DECISION DELEGATED TO HEAD OF PLANNING

Application No: H23-0731-23 **Applicant:** Mr & Mrs I Sloan
Proposal: Proposed Residential Development
Location: Adj Victoria Cottage Stockwell Gate North Whaplode
Terminal Date: 10th October 2023

## Proposed Block Plan

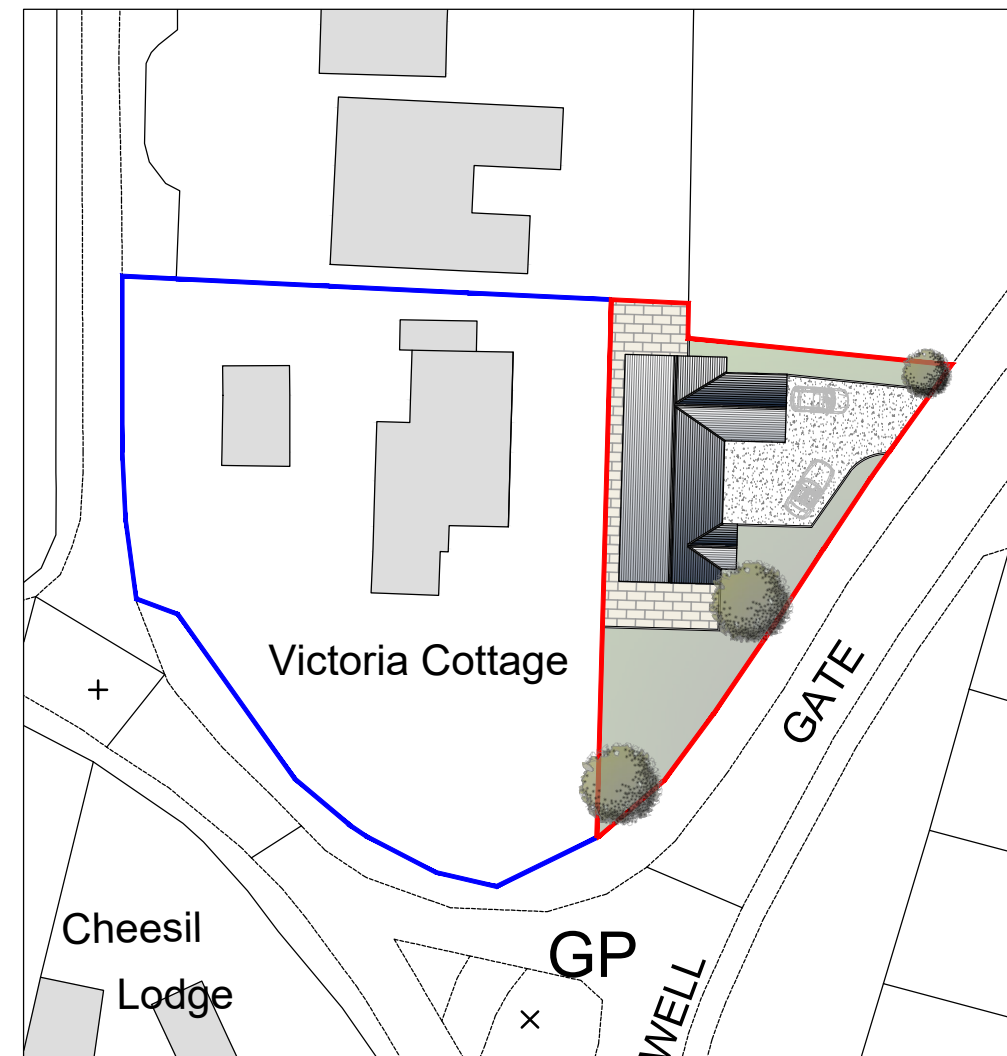
The proposed scale of the development is not out of keeping with the character of the area. There are a variety of properties which are on a large scale and some which are smaller within the area. The size of the plot however is not proportionate to the scale of the proposed dwelling. It would be a cramped form of development due to the amount of room the dwelling will take up on the plot in comparison to other existing plots. Therefore, the proposal does not appear to be in accordance with policies 2 & 3 of the SELLP and Paragraph 130 of the SELLP in regard to the size, mass and bulk.

There is the potential for the property to be either a bungalow or a two storey dwelling. If the proposed dwelling were to be two storey it would significantly overlook the neighbouring property, Victoria Cottage. Due to the close proximity and therefore the closeness of the windows it would reduce privacy and impact amenity to neighbouring properties. Furthermore, the proposed dwelling would also have minimal privacy following the development taking place, the existing property (Victoria Cottage) would overlook from the windows at the house already and therefore the residents of the new dwelling would suffer greatly from a lack of privacy on their part. A bungalow would be most suited for the site due to the chance it will minimise any overshadowing or overlooking, however, if the proposed residential development were to be a bungalow they would again suffer from a lack of privacy and their amenity would be impacted again from Victoria Cottage. However, it is considered that they would not overlook other neighbouring properties. It is still considered to be a significant impact and therefore directly contradicts Policies 2 & 3 of the SELLP and should be refused for this reason as well.

The proposed garden is very small in size when compared to neighbouring plots, this would therefore mean the potential residents who would live there would have unsuitable/inadequate amenity space. There would be some room to the south for a garden however this is the only space for them due to the close proximity of the dwelling the boundary fence at the west.

As the residential development is only for one dwelling it is not considered to create extra undue stress upon the highway. However, there is the potential for some concerns due to the property being situated on a slight bend and therefore the residents who will live here may struggle pulling out onto the road. Despite this, LCC Highways have not objected to this application and have stated that it is acceptable in principle, this would mean that if this application were to be approved sufficient information would be needed during the reserved matters stage for them to assess the development accordingly. As such, it can be considered that the proposal is acceptable in terms of highway safety and is not considered to unacceptably impact highway safety.
